Reference No:	2024/44/93431/W
Site Address:	Land at, Penistone Road, Fenay Bridge, Huddersfield, HD8 0AW
Description:	Discharge of details reserved by conditions 22 (BEMP), 25 (boundary treatment), 30 (retaining wall materials), 32 (external lighting), 34 (waste collection) and 35 (cycle storage) of previous permission 2022/93154 for erection of 68 dwellings with associated access, parking, open space, landscaping and infrastructure works (including installation of surface water attenuation tank)
Recommending Officer:	Katie Chew

DECISION – Discharge of Condition – Refuse

Officer Report:

Application: 2024/93431

Drawing No. 0013 - EXTWKS Rev J

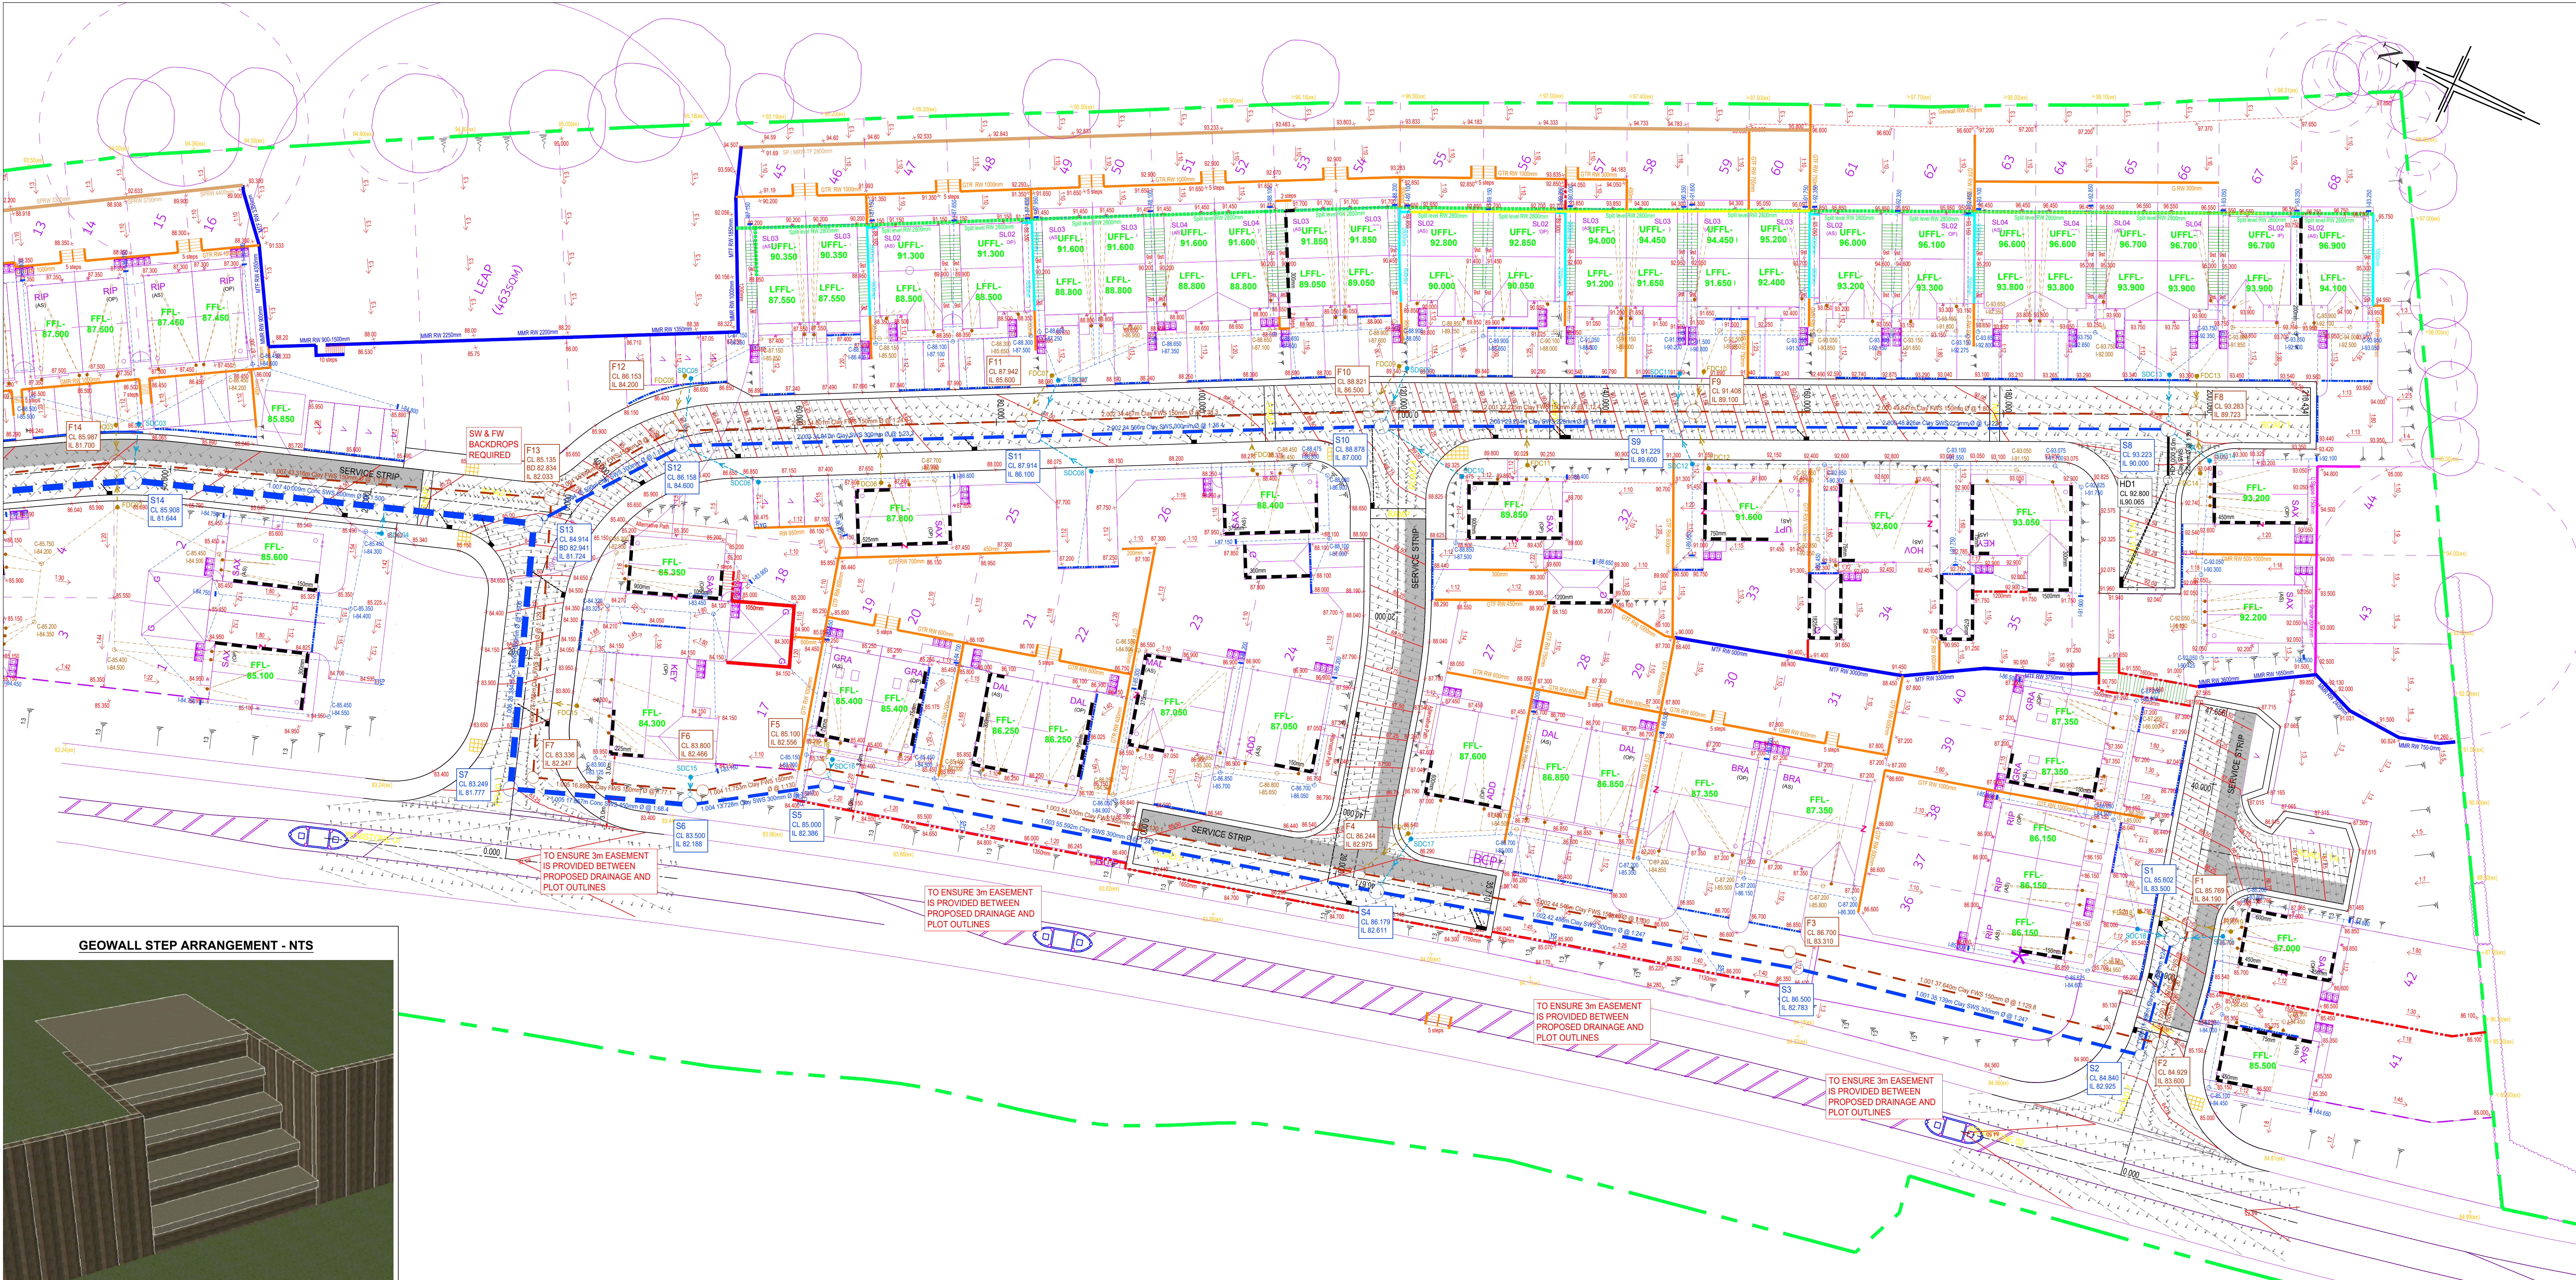
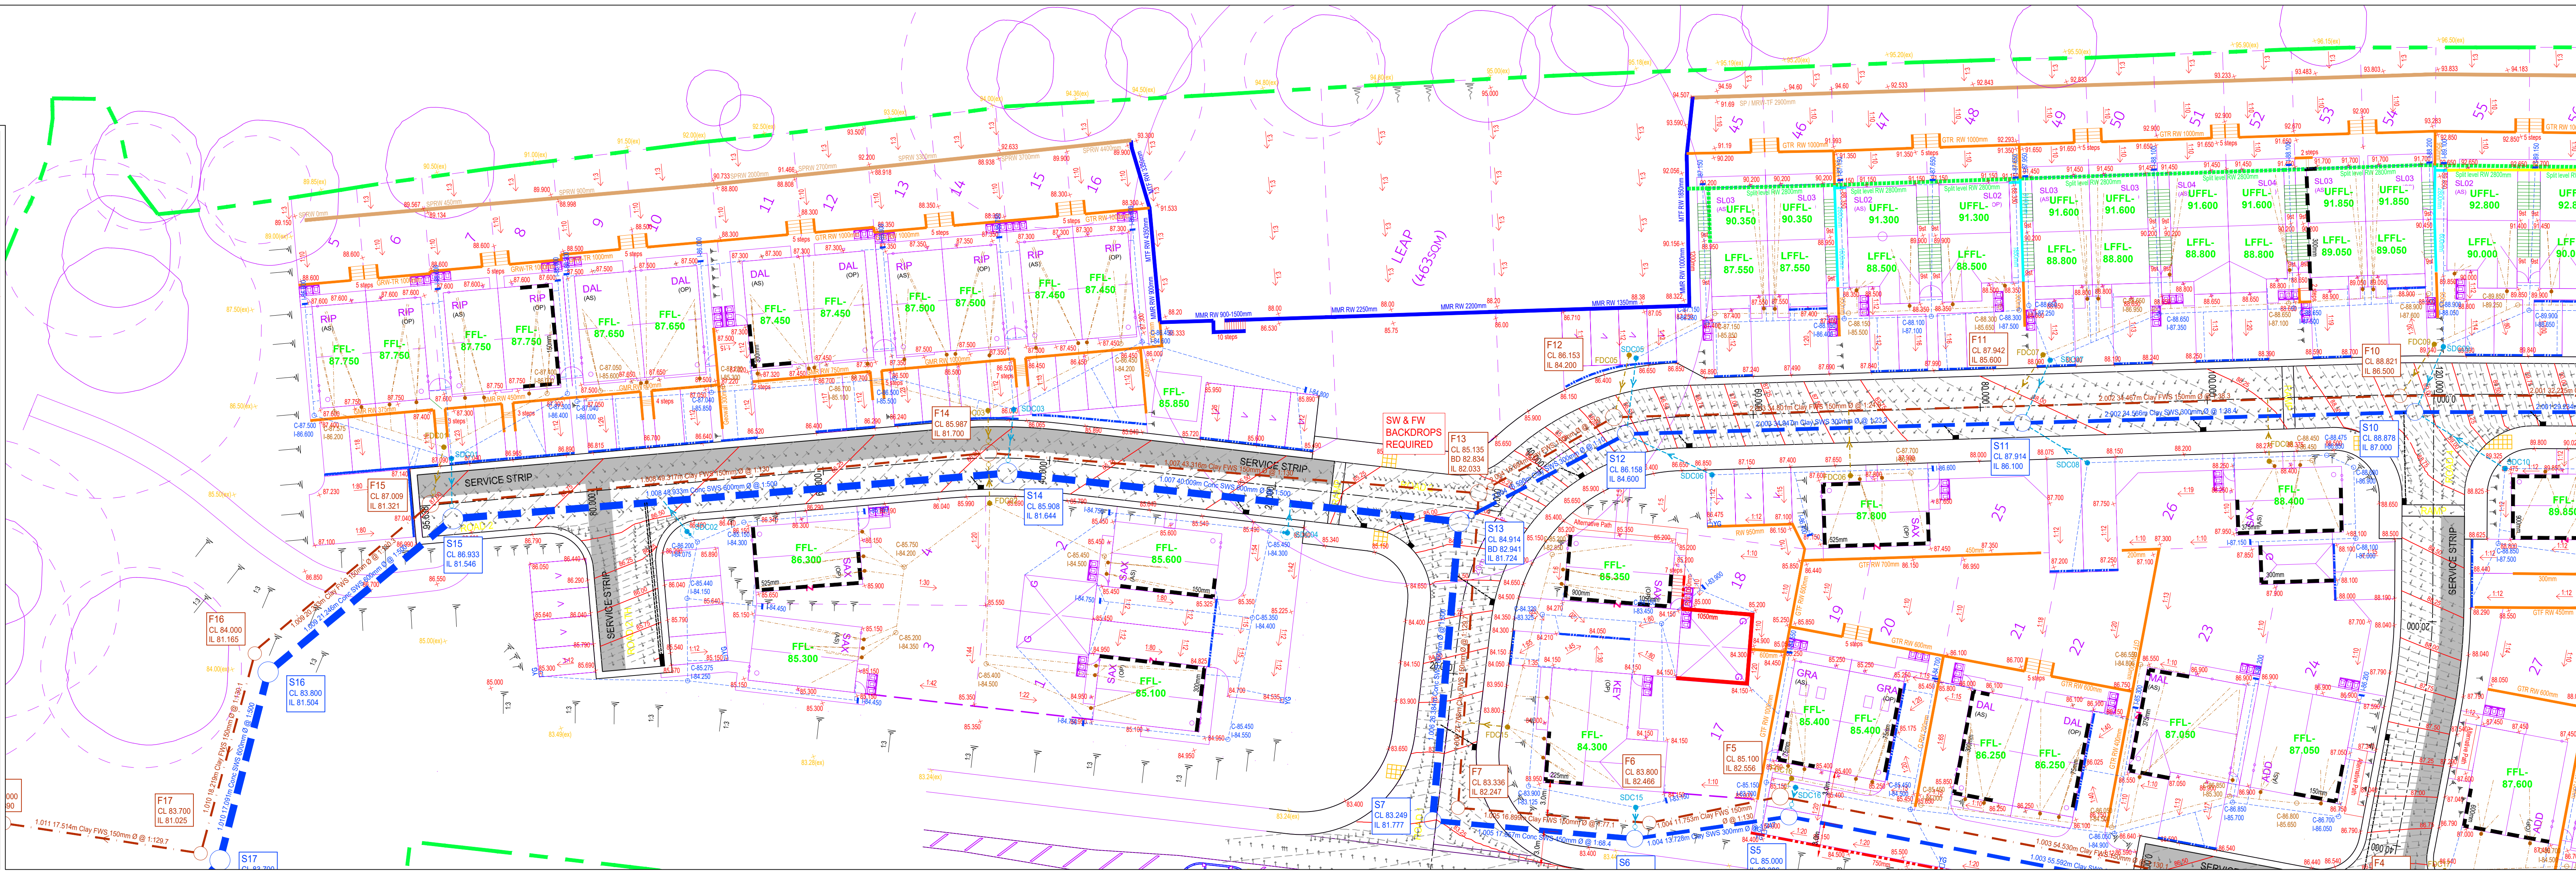
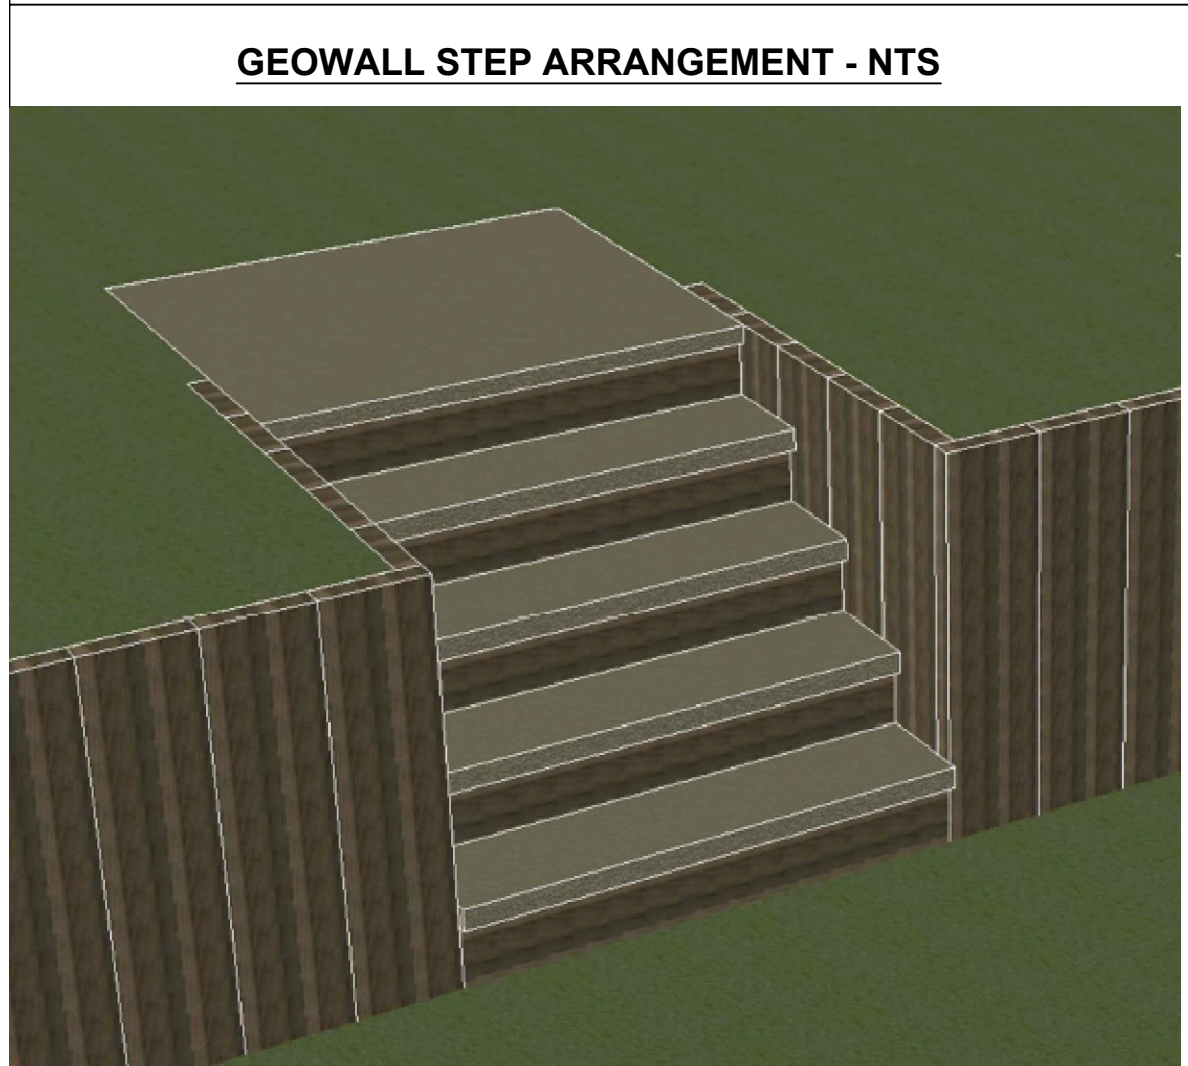
However, it is noted that the originally proposed 1.1m & 1.5m metal guard rail/fencing around the public open space located to the south of the site, adjacent to no. 9 Woodsome Drive has now been removed within the revised boundary treatment plan. This 1.5m high metal fencing was required to ensure that this area of open space is not accessible by the public to prevent use of the area in such proximity to no. 9 resulting in harmful impacts. Without this element Officers cannot support the discharge of this condition. A GeoWall and 1.8m fence is also now proposed within this open space and is not deemed to be acceptable. The proposals should be revised in line with the above.

Mac Walling with timber fencing/metal railings are also proposed around the LEAP, this would not be deemed acceptable and should be in a high-quality natural stone.

Finally, to the front of plots 5-16 a GeoWall and 1.1m metal railings are now proposed. Whilst this may be acceptable no details have been provided to explain why this is now required.

DRAWING TITLE:	Typical Shed Arrangement
----------------	--------------------------

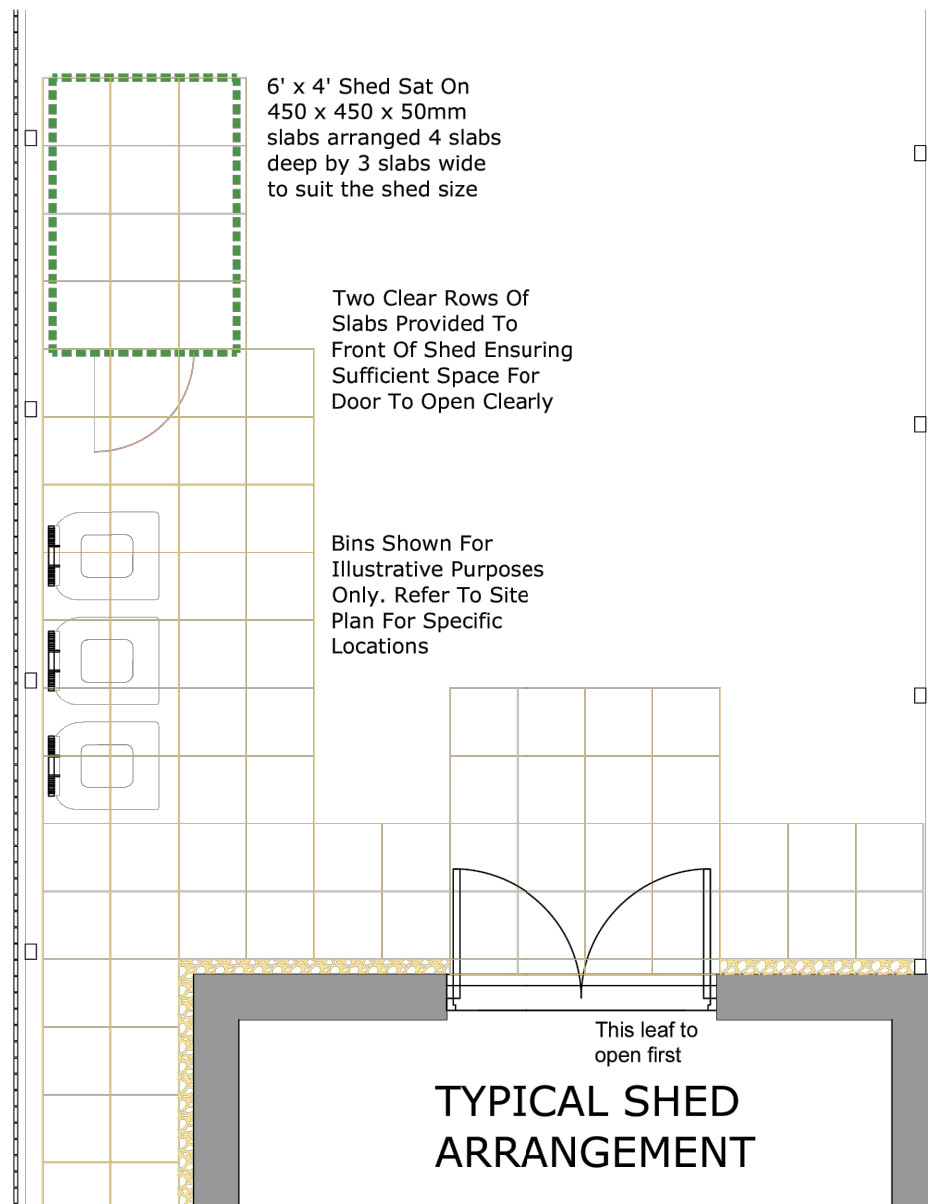
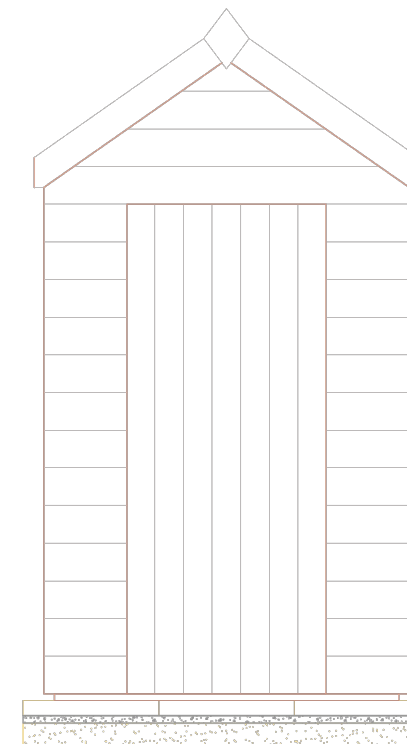
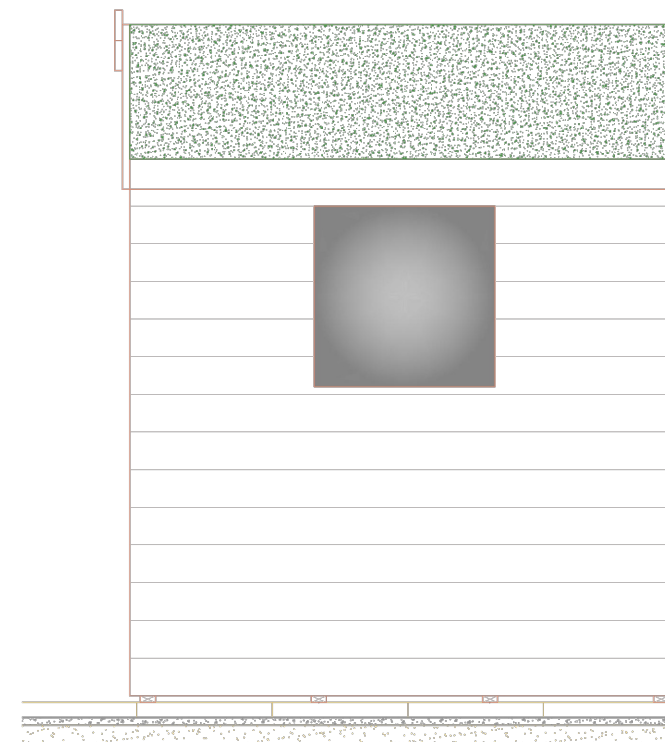
Whilst the above details are considered to be acceptable in scale and design and would provide suitable covered cycle storage for the dwellings. No details

have been shown on plan in respect of which plots within the site are to benefit from these sheds, and where they are to be located within individual curtilages. It is noted that properties with garages would not require the provision of such outbuilding.
